## OzArk Response to OEH Queries over the Tomingley Gold Project Biodiversity Offset Strategy and BioBanking Credit Calculations

### **Re: Alkane Resources Pty Limited Tomingley Gold Project**

In response to correspondence from Mr Brad Tanswell of the NSW Environmental Protection Authority (EPA) dated 15/12/2011 the following responses have been provided as requested and responses supplied:

Figure 2.19
BIODIVERSITY OFFSET STRATEGY

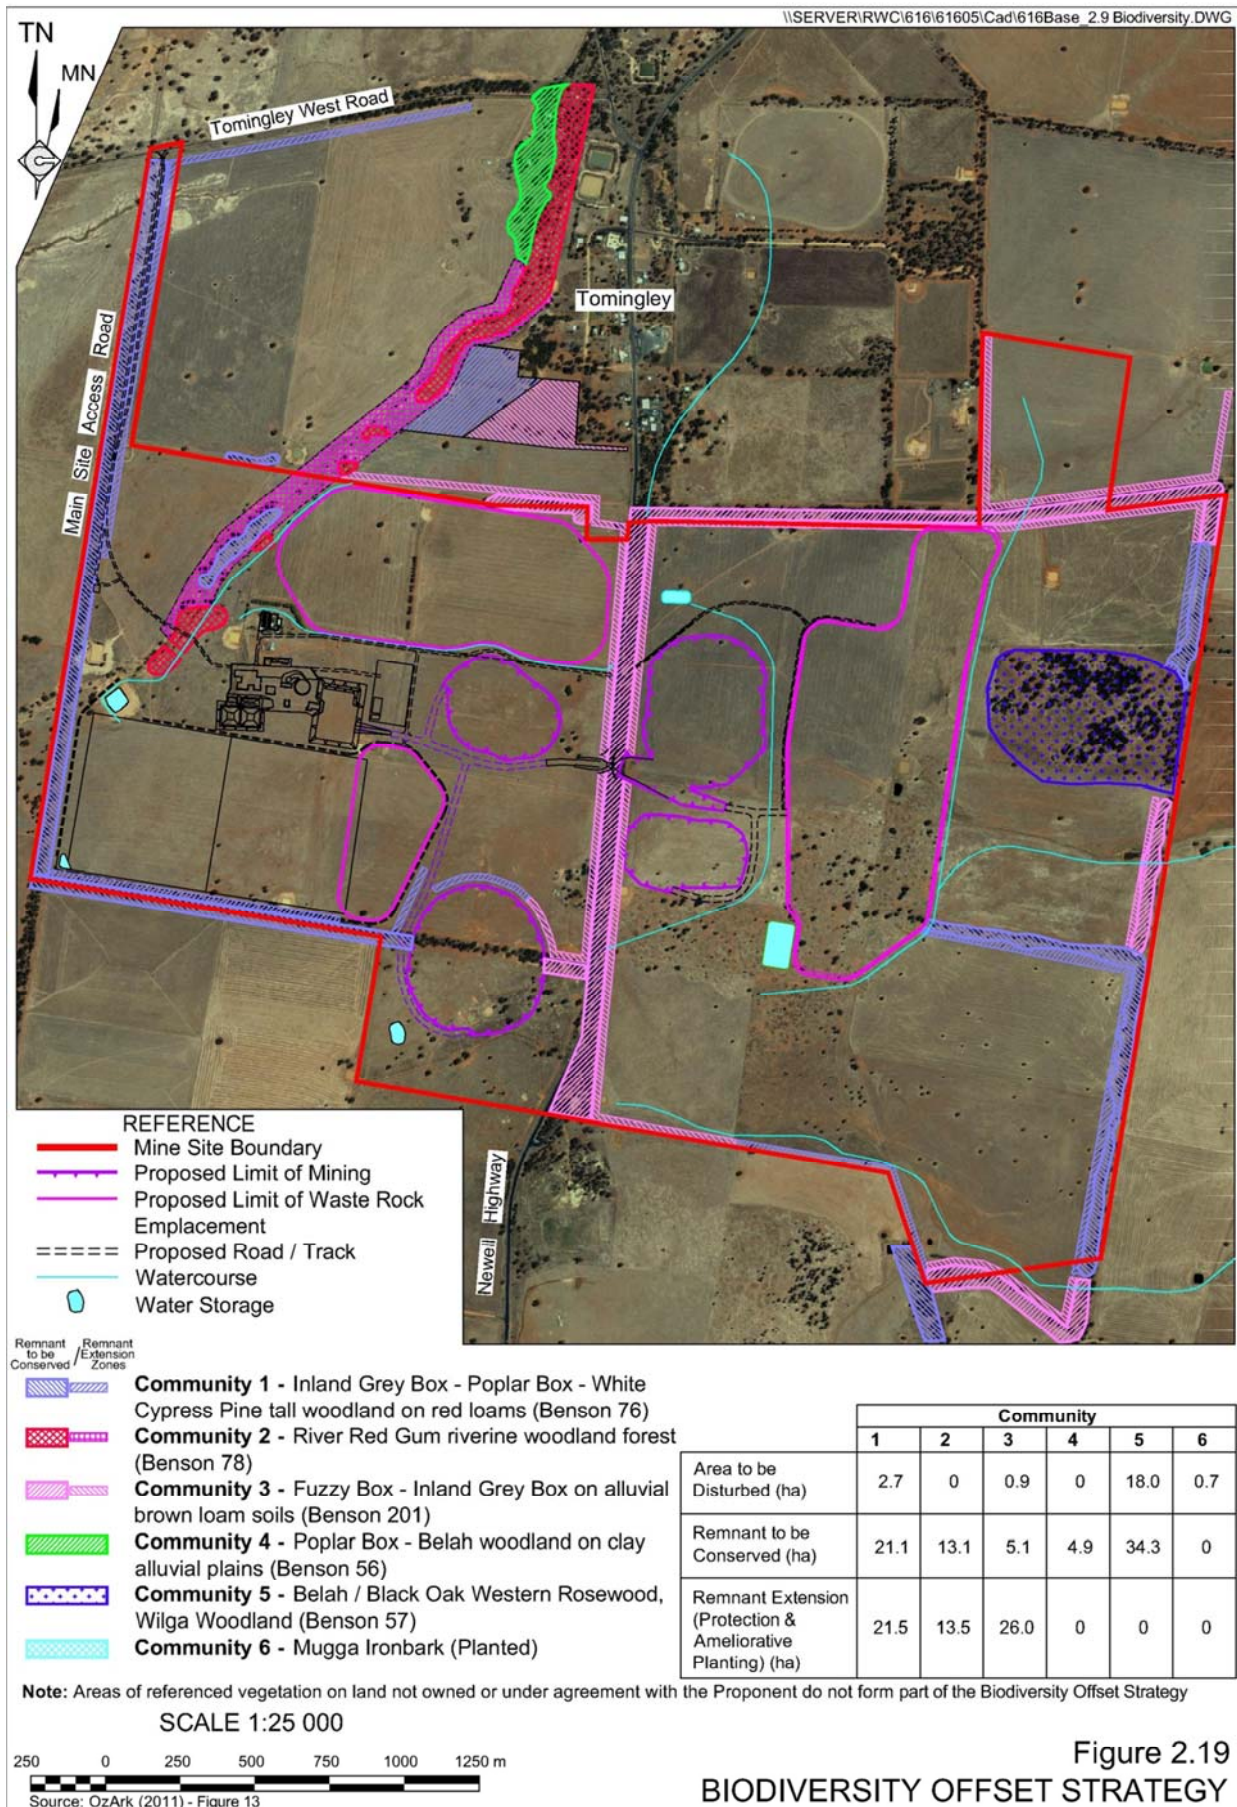
**Issue:** Some inaccuracies remain in the proposed Biodiversity Offset Strategy (BOS). Clarification of the area to be included in the offset is required.

**Response:** The Proponent has re-issued a figure (**Figure 2.19 (Modified)**) showing the location of offsets (vegetated area to be removed has not been highlighted). You will note that there are two main changes to the areas identified on the original *Figure 2.19* of the Environmental Assessment (and *Figures A10.1 and A10.2* of the Biodiversity Assessment) and included in the BioBanking credit calculations.

1. To accommodate the Eastern Surface Water Drainage Structure the Proponent will be required to remove a small (30m x 30m) patch from the remnant vegetation (of Community 3). This has increased disturbance by 0.1ha and reduced conservation by 0.1ha.
2. The area of Community 4 conserved has been reduced to 1.9ha as it has been identified that 3.0ha of the original area was located on land for which the Proponent holds an agreement with the land owner. It is noted that areas to the south of the Mine Site on the eastern side of the Newell Highway identified in the

original Figure 2.19 were not included in BioBanking calculations and have also been removed from Figure 2.19 (modified).
